**KIRKLEES METROPOLITAN COUNCIL
INVESTMENT & REGENERATION SERVICE**

DELEGATED DECISION TO DETERMINE PLANNING APPLICATIONS

Reference No:	2023/62/92156/E
Site Address:	120, Staincliffe Road, Westborough, Dewsbury, WF13 4RP
Description:	Alterations to convert lower ground and ground floor retail unit to two flats
Recommending Officer:	Nicole Helliwell

Officer Report

PROPOSED LOWER GROUND FLOOR PLAN

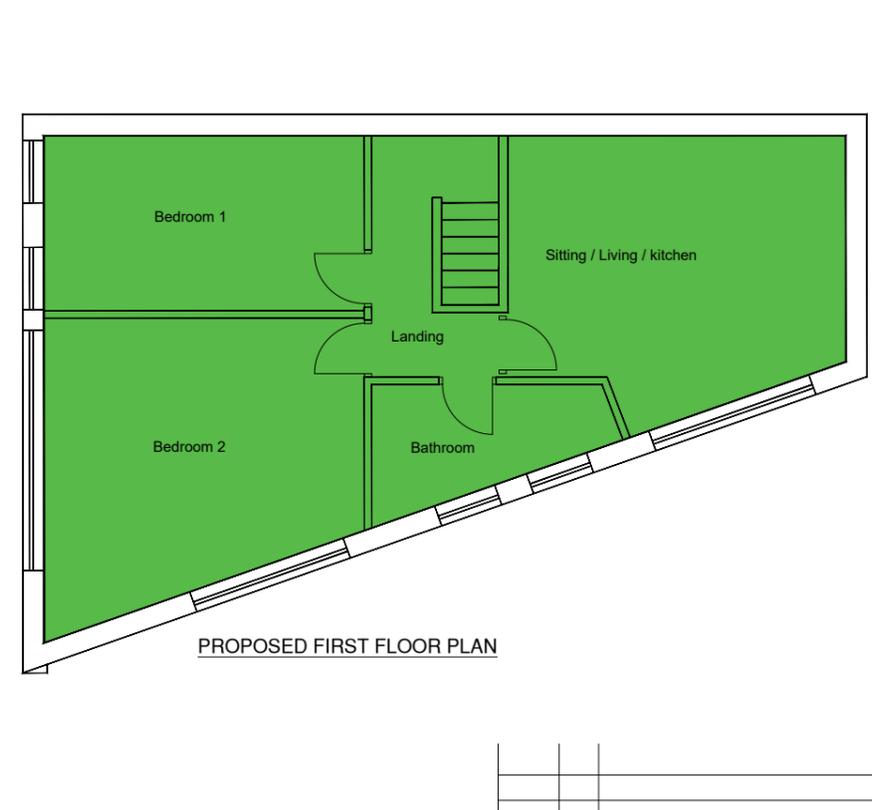
The proposed floor plans show that the duplex flat would have one bed space and therefore is required to have an internal floor space of 58m². The proposal is shown to have an internal floor space of 43.4m² which would fail to accord with the national described space standards. Furthermore, the proposed floor plans show that the one storey flat would have one bed space and therefore is required to have a minimum internal floor space of 39m². The proposal is shown to have an internal floor space of 34.6m² which would also fail to comply with the national described space standards. Therefore, it is considered that the proposal would provide an unacceptable standard of living for future occupants and would fail to accord with LP24(b) of the Kirklees Local Plan, Principles 6 and 16 of the Council's Housebuilders Design Guide SPD, and Paragraph 135 (f) of the National Planning Policy Framework.

1. The proposed lower ground and ground floor flats would fail to accord with the Nationally Described Space Standards and would provide an unacceptable standard of living for future occupants. The proposal would be contrary to Policy LP24(b) of the Kirklees Local Plan, Principle 16 of the Council's Housebuilders Design Guide SPD, and Paragraph 135(f) of the National Planning Policy Framework.
